Our ref: DOC20/509024

Senders ref: SSD10425

**Subject: Clarification on BDAR or BDAR Waiver for Tallawong Station Precinct South – Stage 2 Detailed Design (SSD10425)**

EES has reviewed the Flood Impact Assessment report (FIA) prepared by AECOM dated 16 April 2020 and considered that the report is inadequate due to the following reasons:

FIGURE B3 FLOOD RESULTS EXISTING CASE - 5% AEP

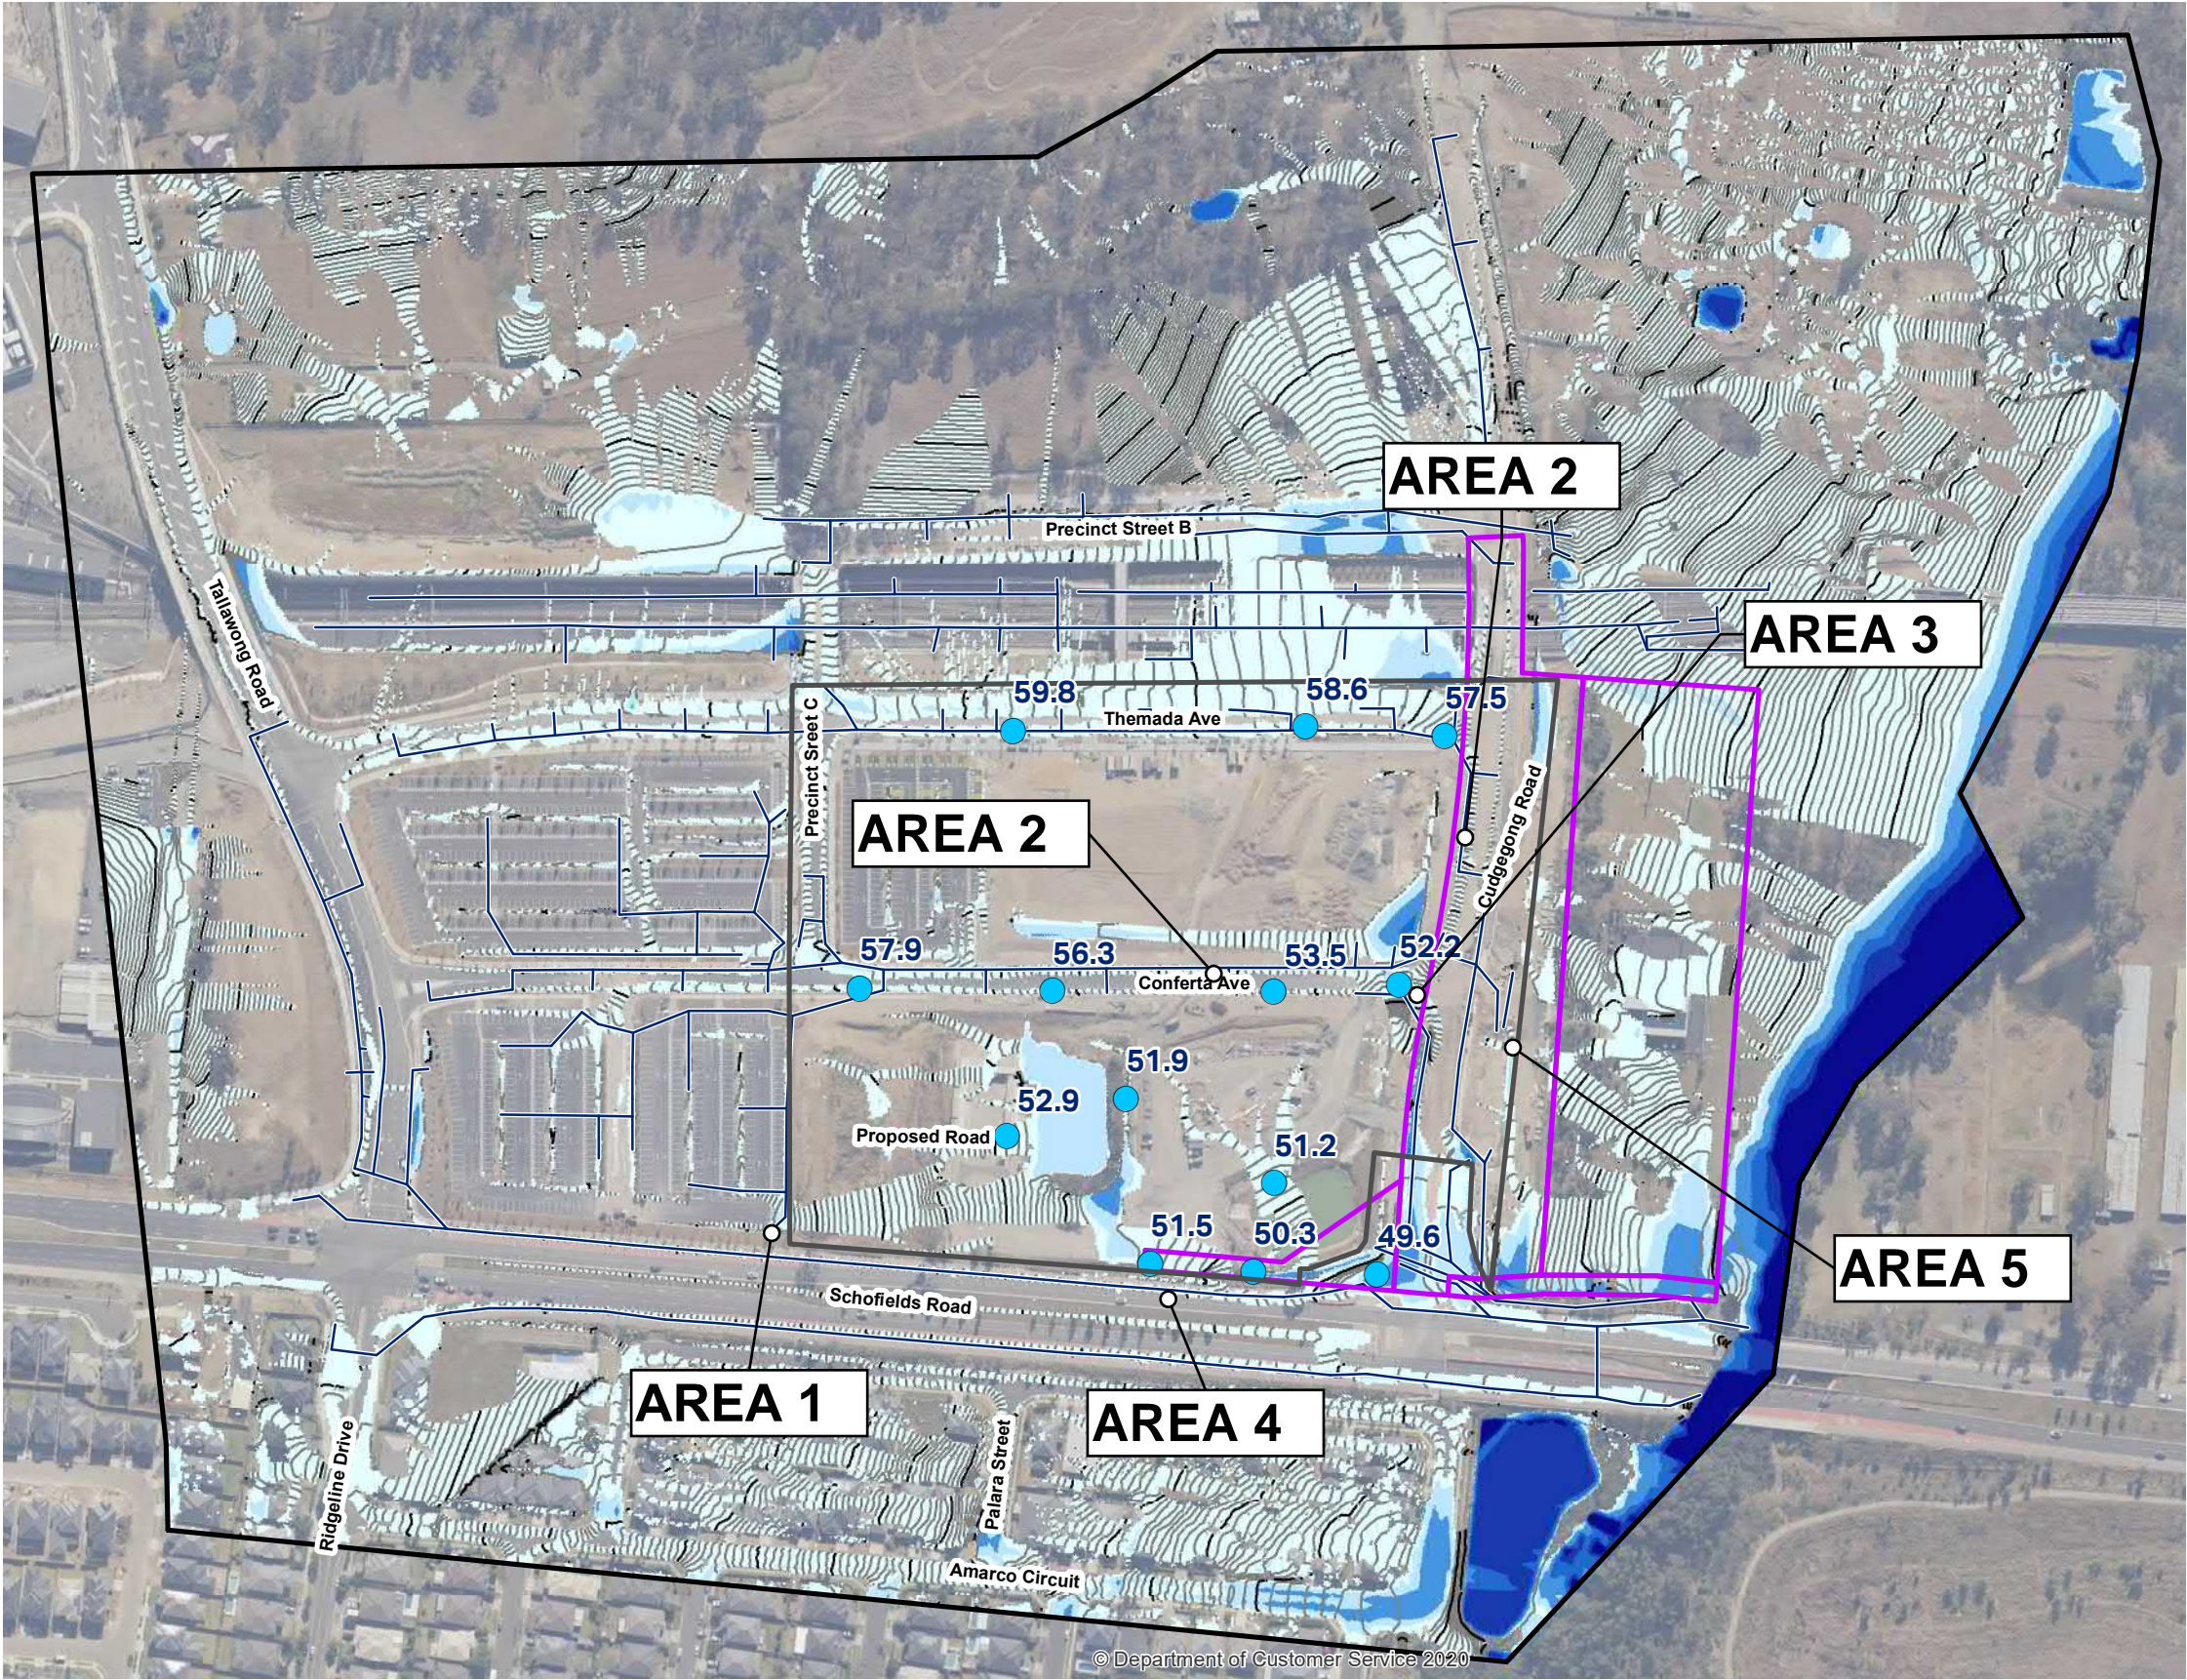
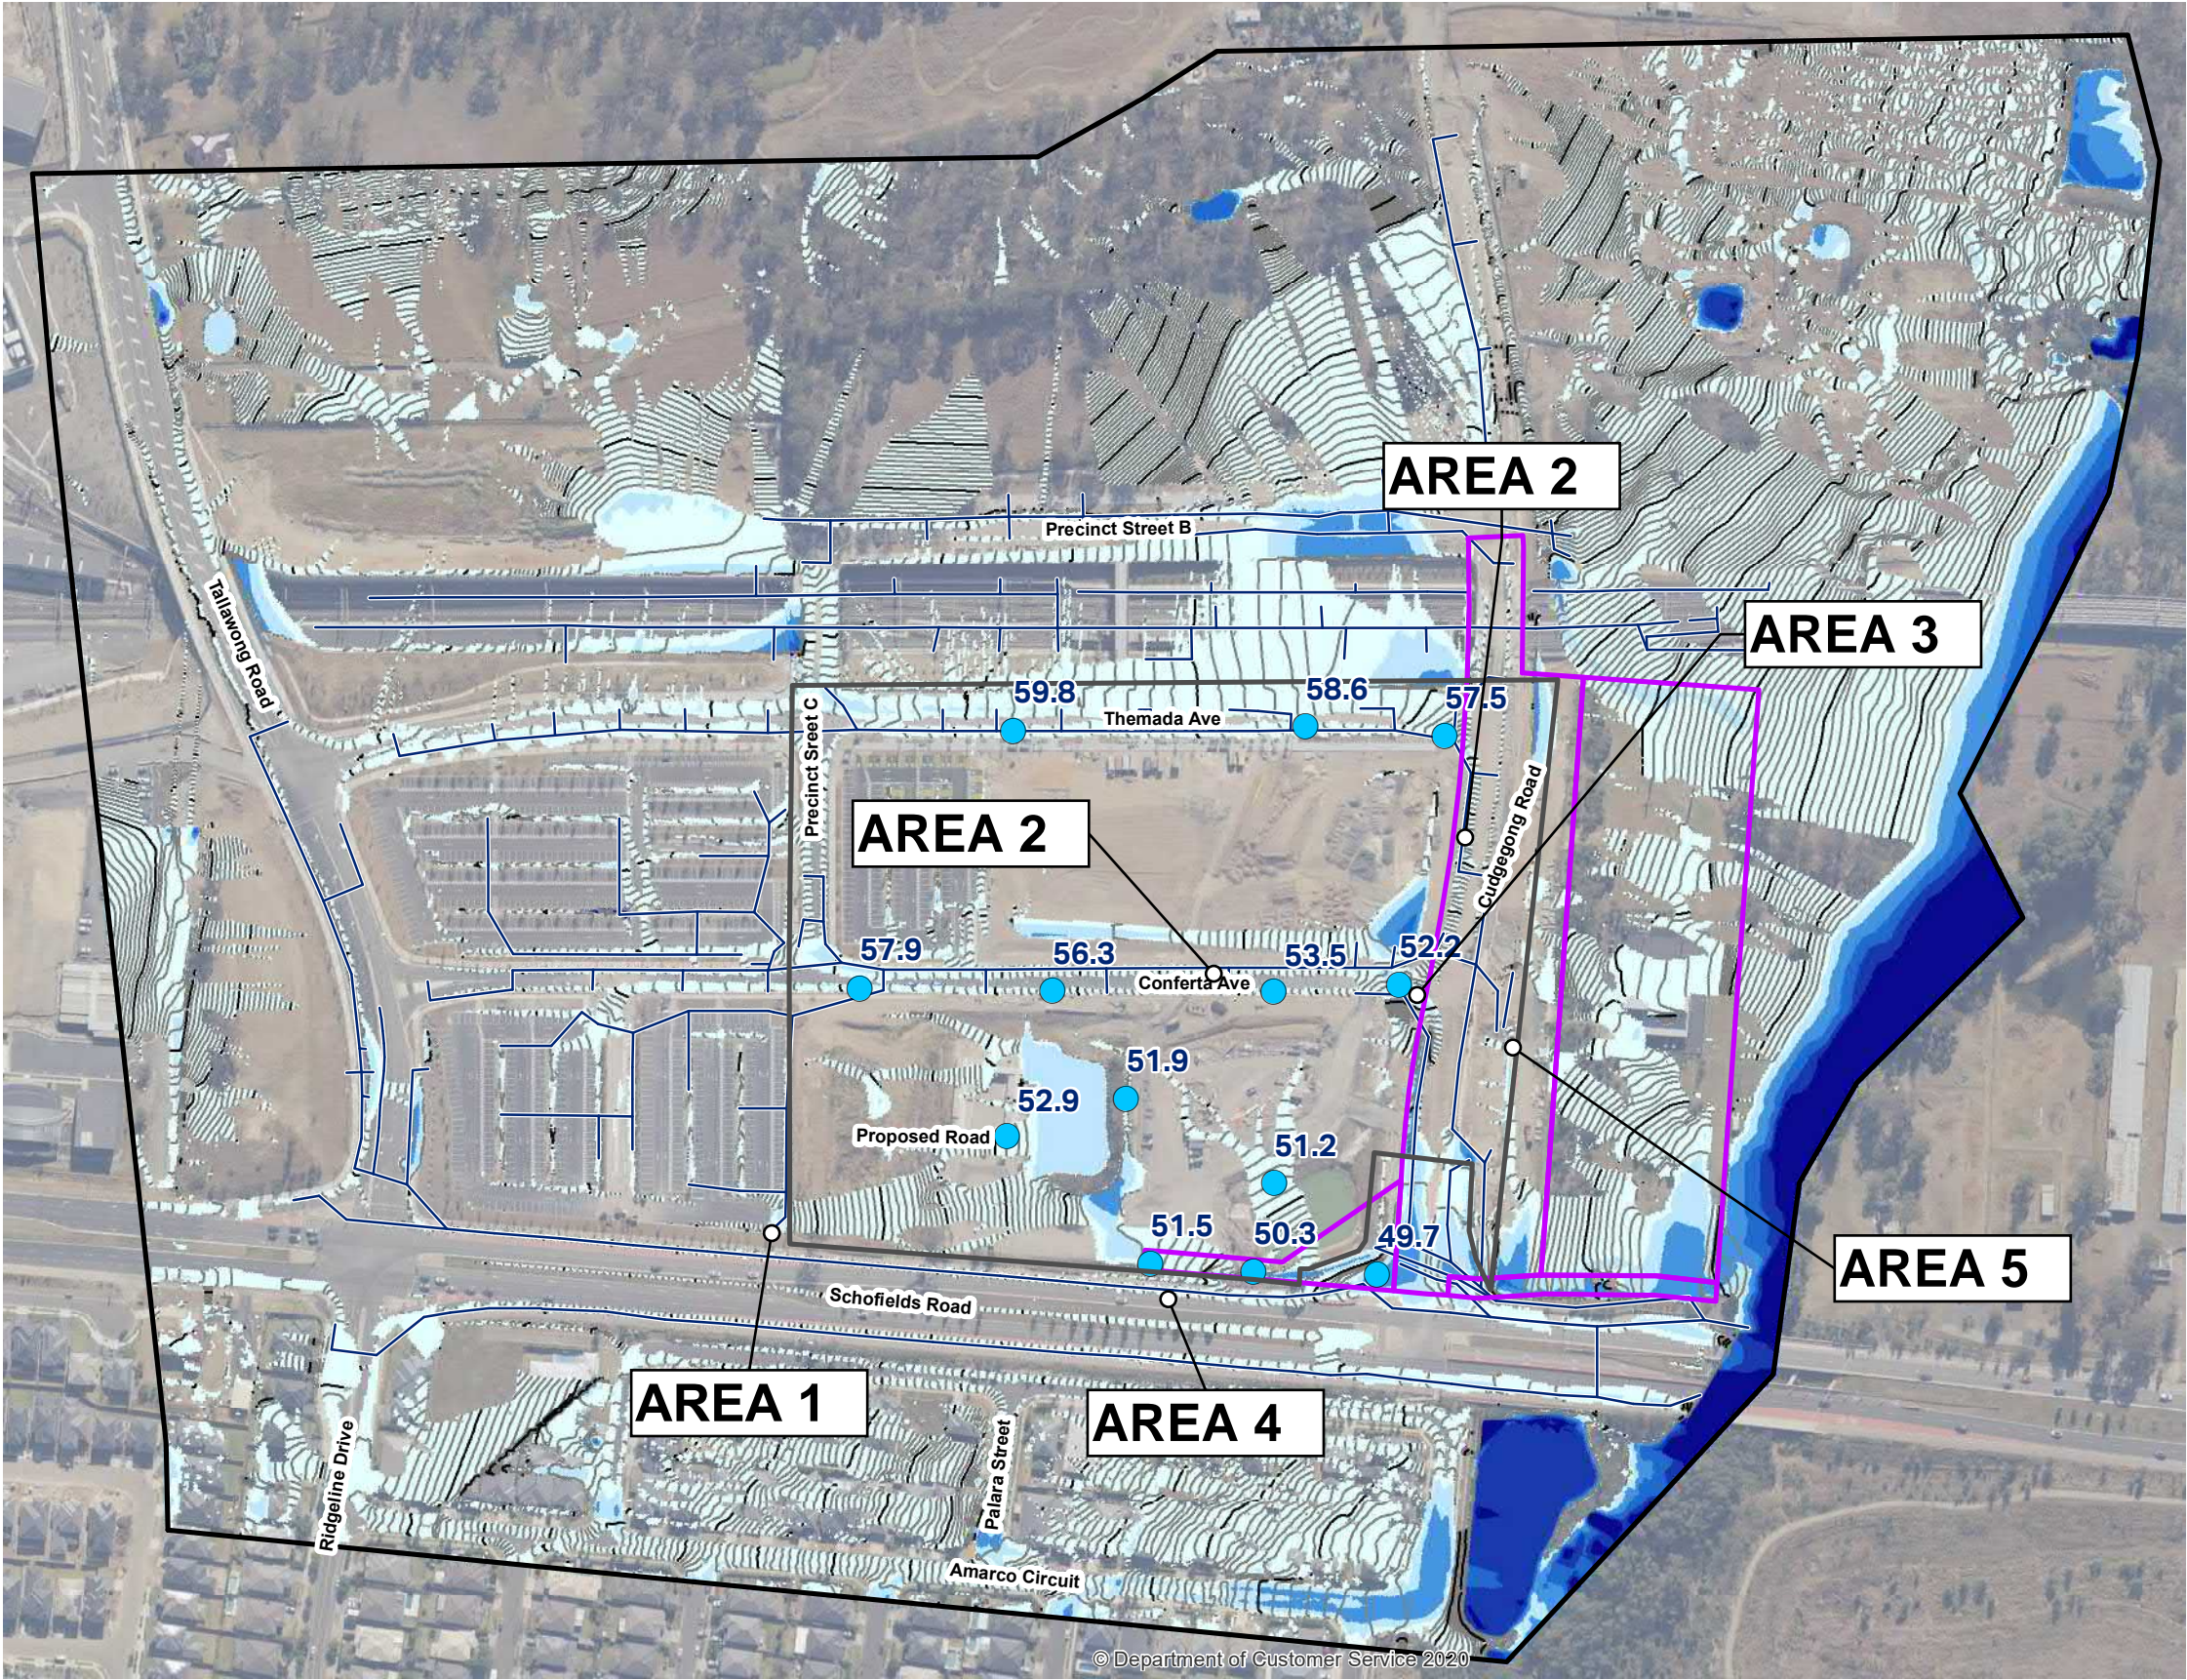
- the report provides no information on existing flood behaviour
- the report lacks details on model results
- not clear what is the extent of the model
- the limit of maps does not show the impacts of development outside of the site, the assessment should map the site and adjacent areas (i.e. to Second Ponds Creek to the west and at the inflow locations where the boundaries of the model were set up).

It is acknowledged from the brief discussion in the report that the consultant has undertaken a rainfall on grid TUFLOW modelling. However, the purpose of a FIA is to outline the flood risk at the site and outline how this risk is to be managed. This would include addressing the following floodplain risk management aspects to assist and guide decision-making at this planning stage:

- existing flood behaviour for the full range of flooding
- impact of development on flood behaviour the full range of flooding
- impact of flooding on development the full range of flooding and assess the compatibility of the proposed development with flood risk
- emergency management consideration (if applicable).
